**Re: Major Projects – New Request for Advice - Yennora Liquid Waste Treatment Plant (SSD-10407)**

Please find below comments from Cumberland Council below:

Figure 3-1: Proposed floor plan for 14 Kiara Crescent

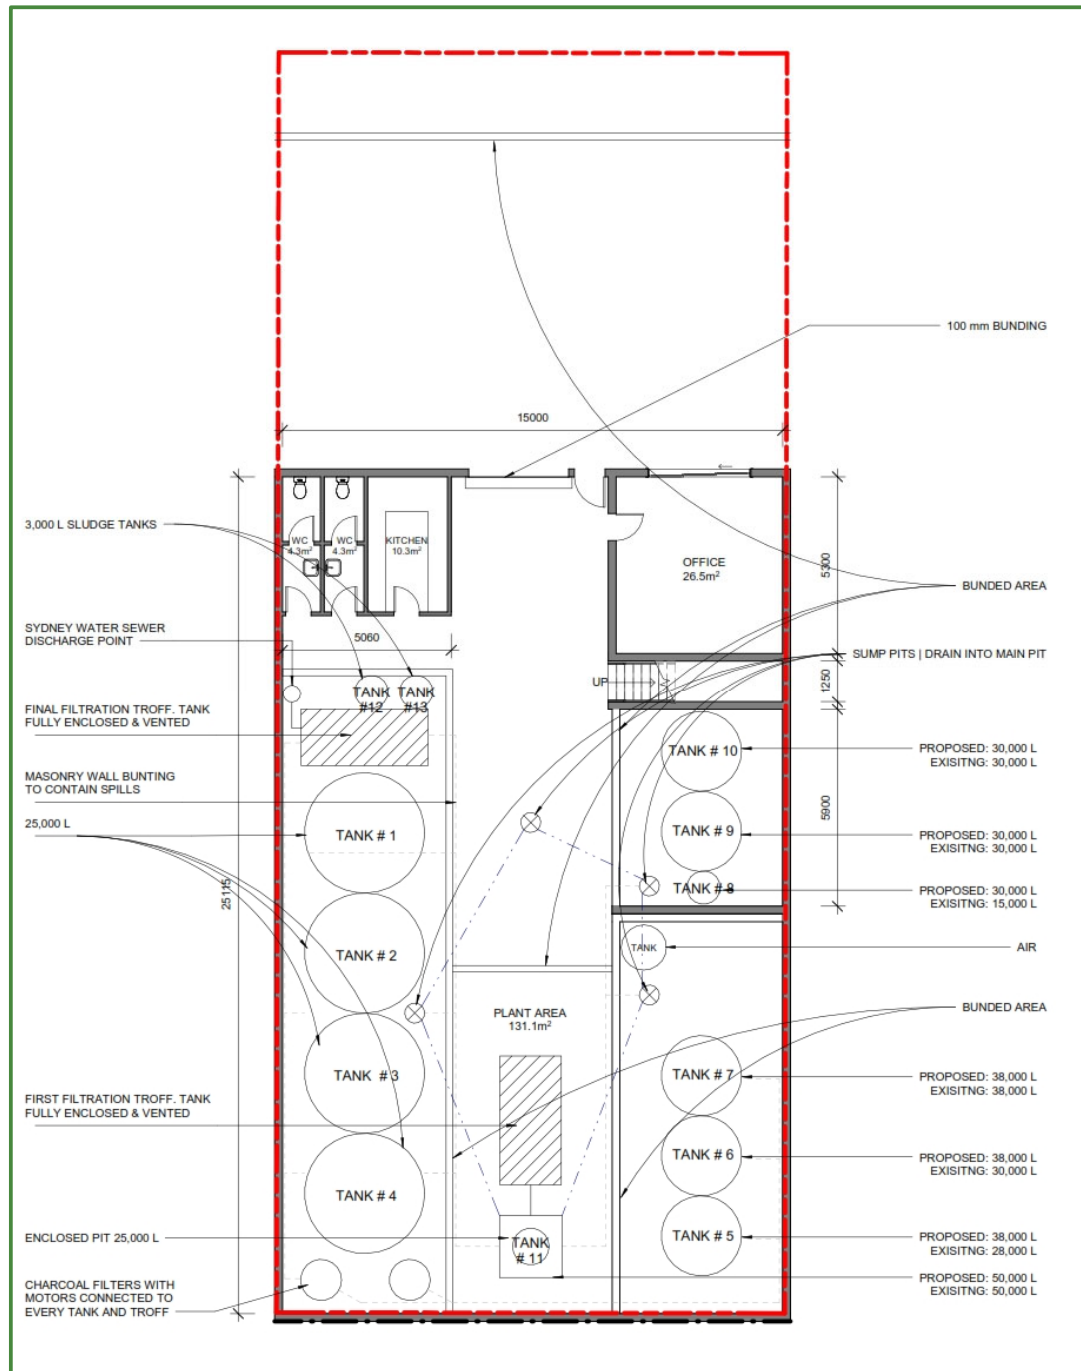
The scoping report states that the applicant does not propose any constructional changes to the site and advises that the existing setup will accommodate for the additional waste. It is advised that the business submit to Council processing details and a site layout plan as to how the business will be able to accommodate for the additional 99,100 tonnes of additional waste per year without the addition of new equipment used for processing or additional space.

Detailed existing and future site plans should be submitted to demonstrate the location of all equipment/machinery (and details as to what this equipment/machinery is used for), as well as the details of any stockpile locations of waste/material, parking of vehicles/trucks and any other equipment internally or externally used at this site.

Figure 2.1. Swept paths for heavy vehicles accessing the site at 14- 16 Kiora Crescent, Yennora. NSW Surveys PTY LTD, 8/11/19.

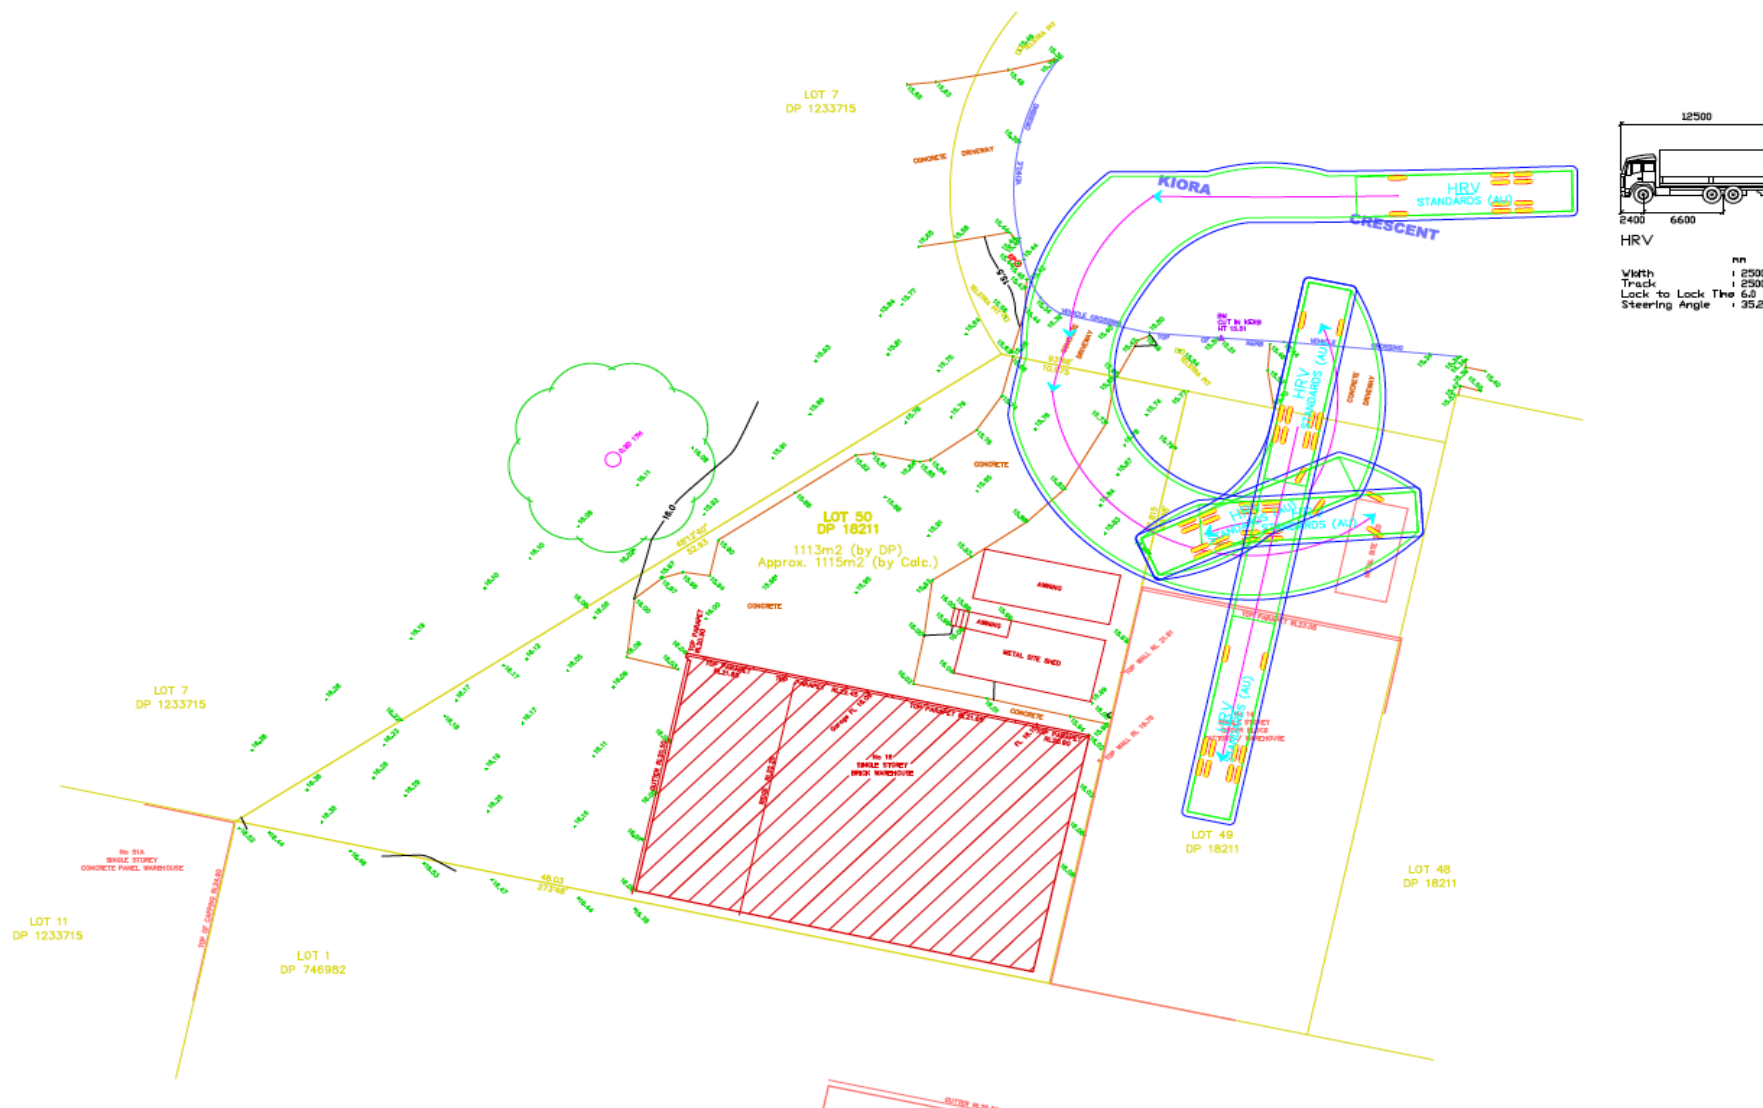
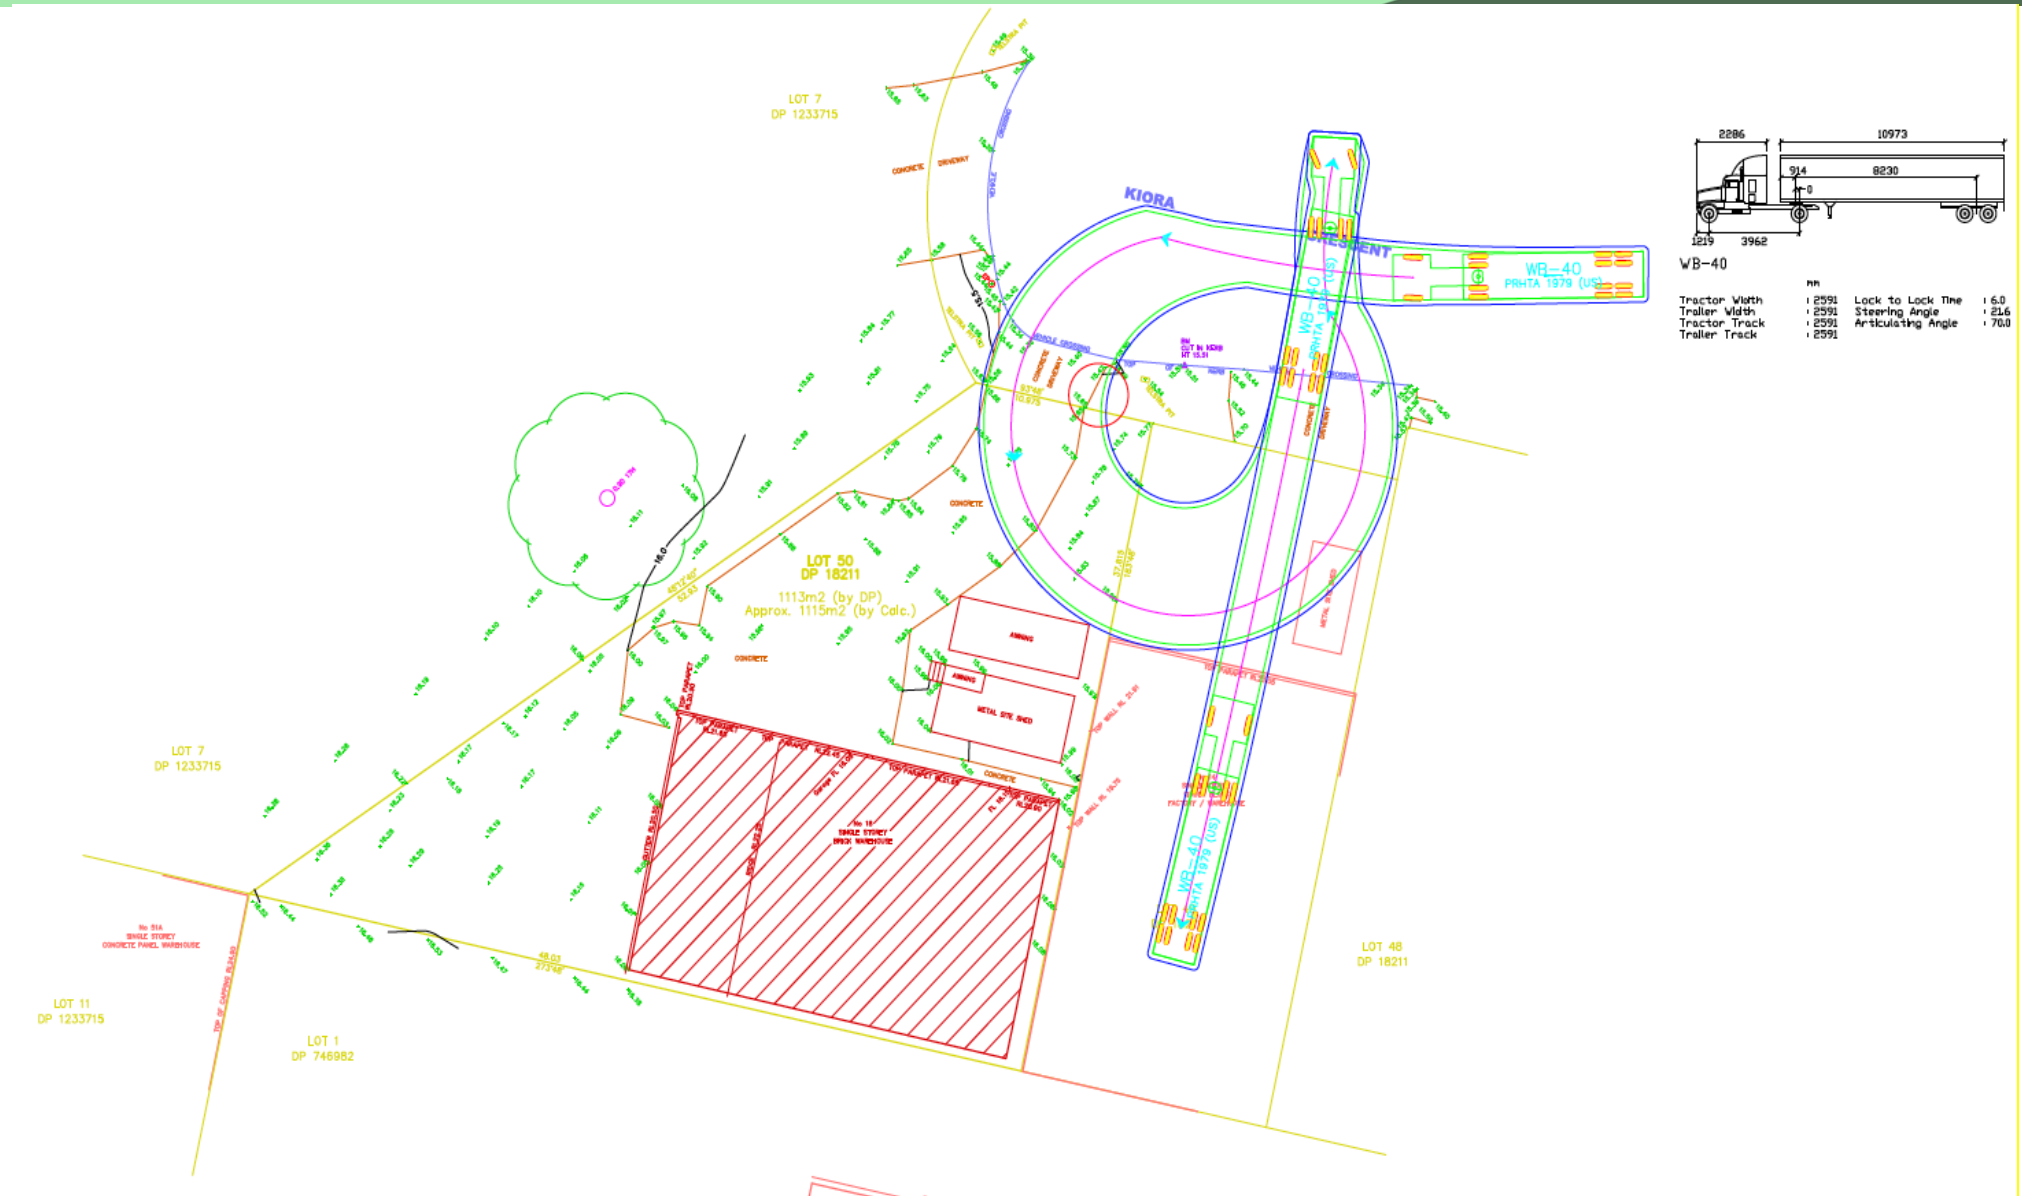
Proposed swept path analysis is not acceptable. The swept path analysis shows that the turning path encroaches into Council footpath and nature strip.

Reverse manoeuvring in Council's land is not acceptable. It will compromise the safety. Vehicles should enter and leave the site in a forward direction.

Proposed 4 point turn truck manoeuvring movement is not acceptable. Manoeuvring shall be limited to three point turn.

Truck swept path interferes with the car parking space.
